My reference: 3/2024/1017
Direct Dial: (01200) 425111
www.ribblevalley.gov.uk
Email: planning@ribblevalley.gov.uk
Date: 13 February 2025

Location: Talbot Hotel 5 Talbot Street Chipping PR3 2QE

Proposal: Approval of details reserved by conditions 4 (details of windows and doors), 18 (landscaping plan/tree planting) and 20 (curtilage/boundary treatment) of planning permission 3/2023/0085.

Client		
Taylor and Doody		
Job Title		
Proposed Alterations to Talbot Hotel Talbot Street Chipping		
Drawing Title		
Proposed Site Plan		
Scale	Date	Drawn
1:200 @ A1	November 24	BWT

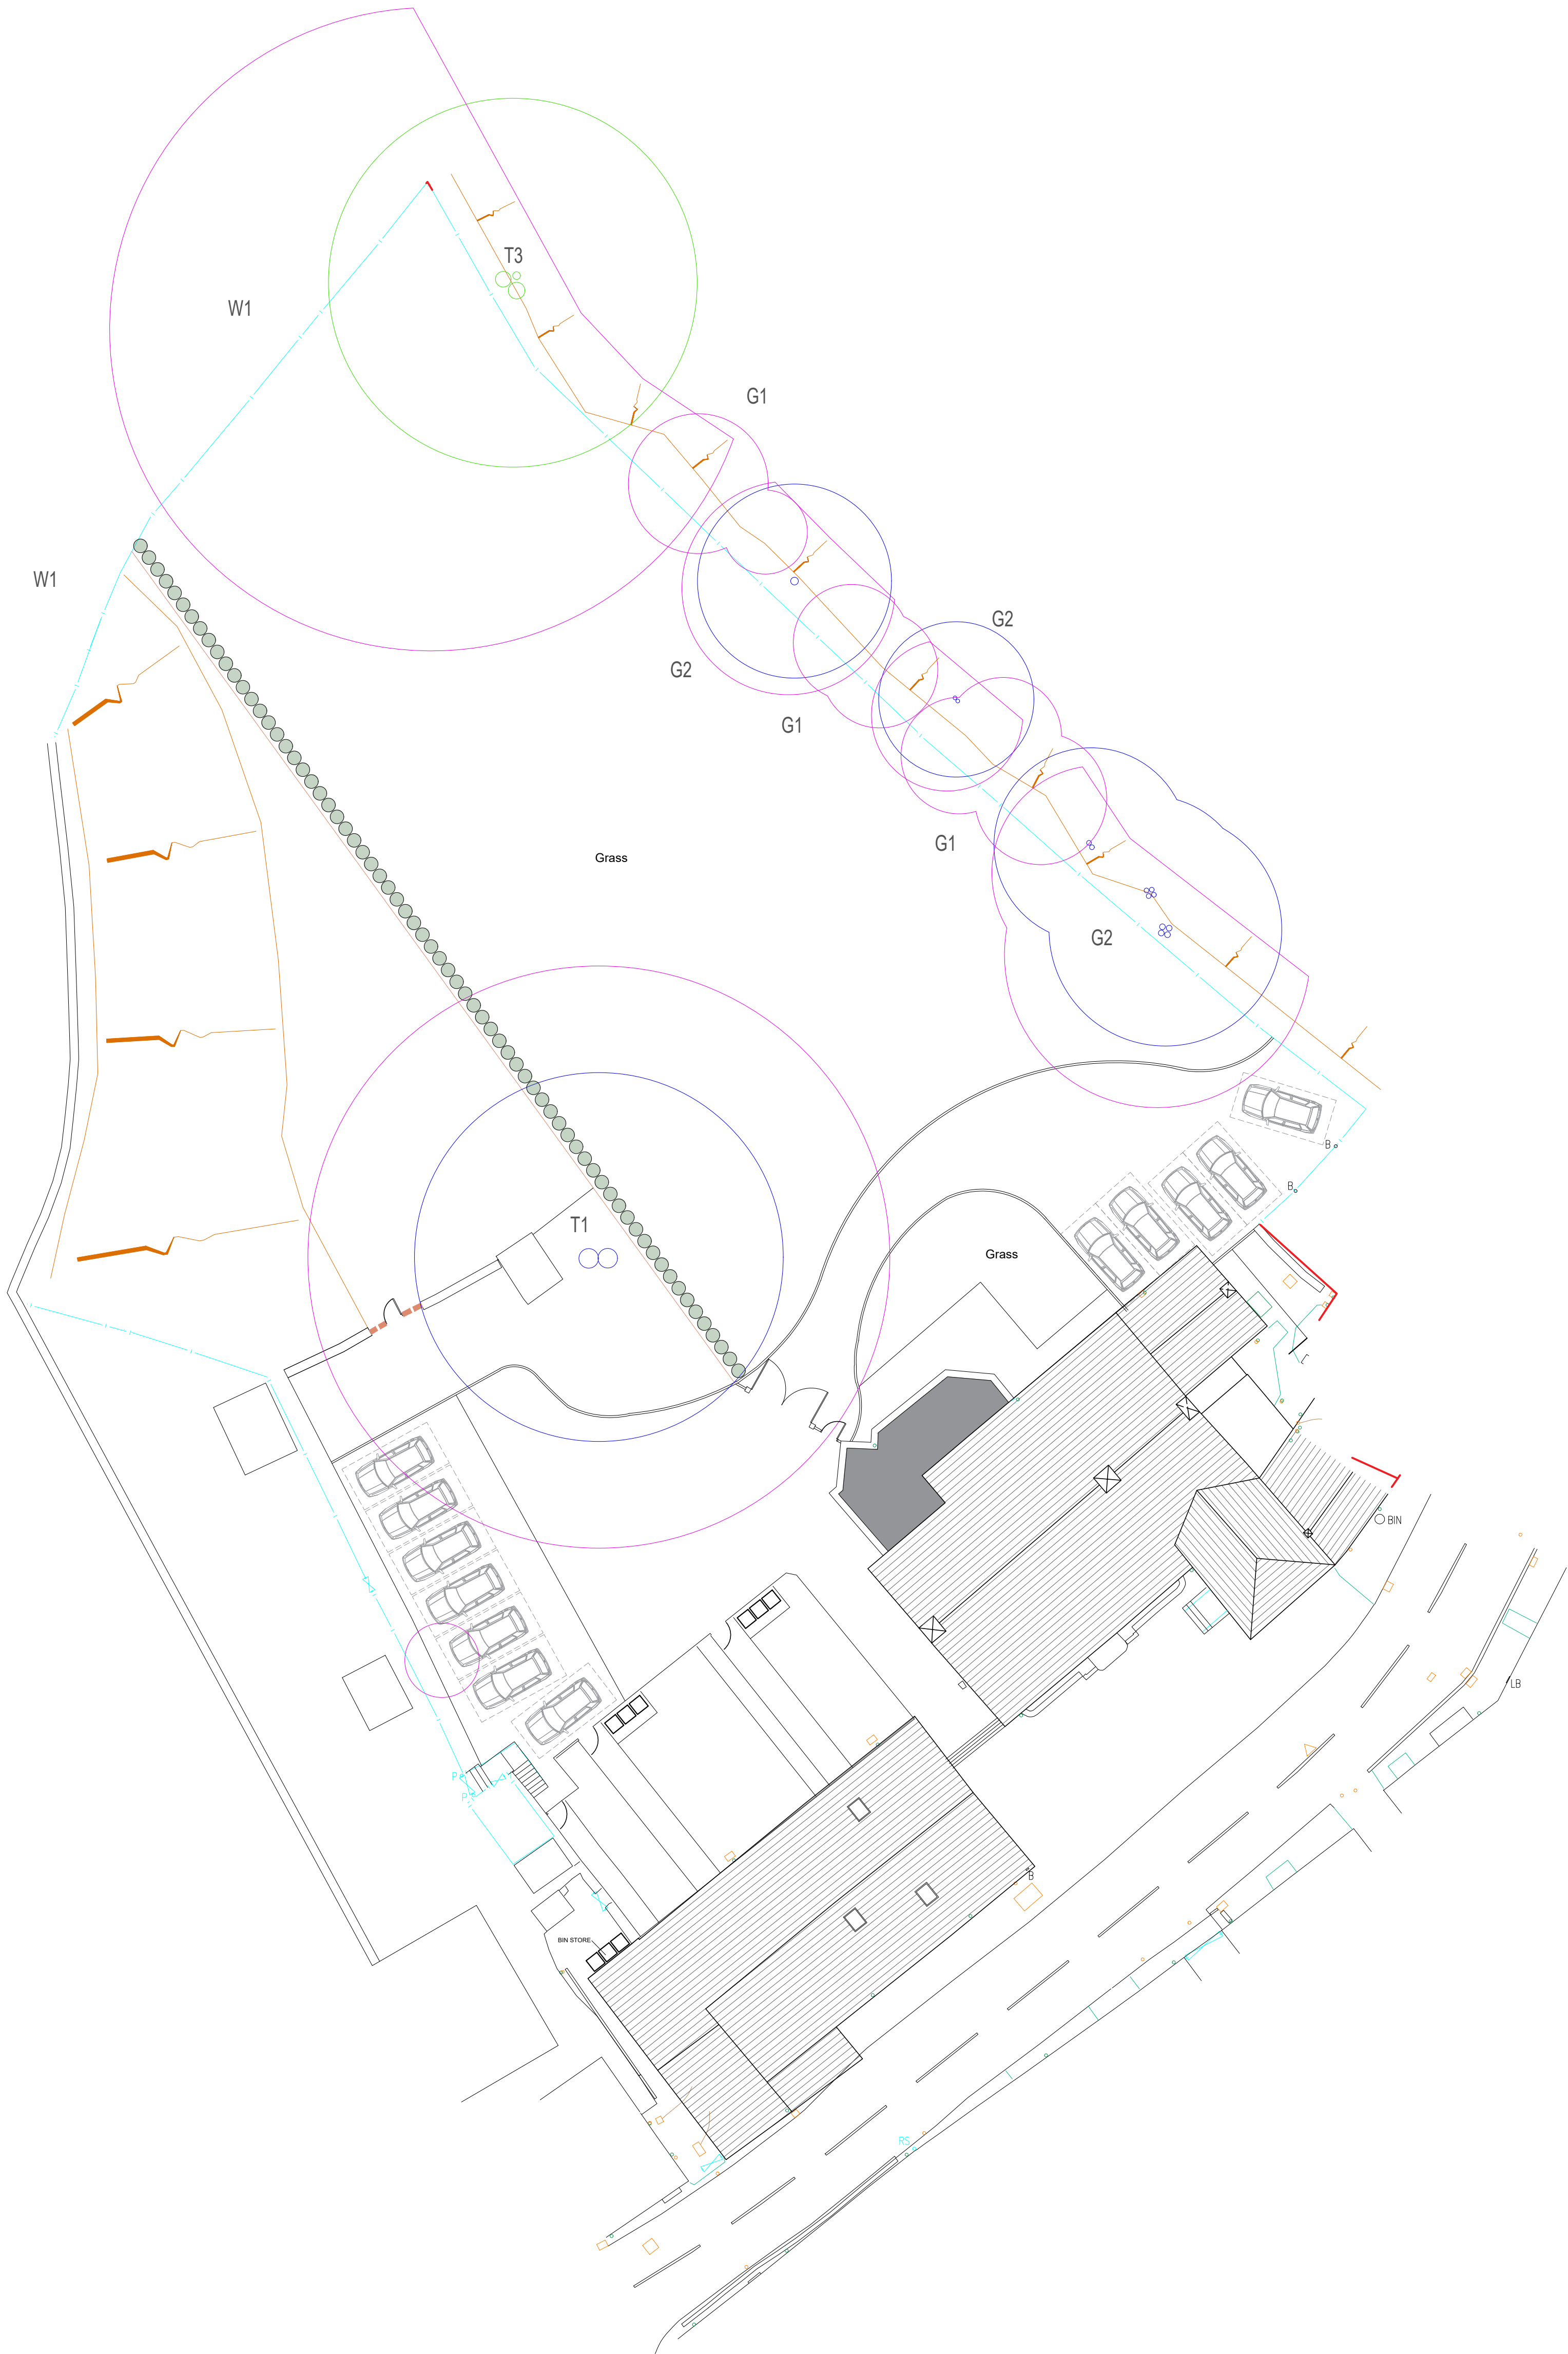
Condition 20 (Curtilage /Boundary Treatment) can be partially discharged in so far as the details shown on the Proposed Site Plan 6521-DOC5 dated November 24 for the vehicle/pedestrian gates and fencing and laurel hedge planting are acceptable. The development shall be carried out in strict accordance with details hereby approved.

The Cherry Laurel to be planted within the RPA of T1 Sycamore tree must be planted at distances which fully take account of the tree roots of the existing Sycamore tree in order to ensure that no root loss occurs that would undermine the life expectancy of the tree and excavated by land as per approved Arboricultural Impact Assessment dated March, 2022.
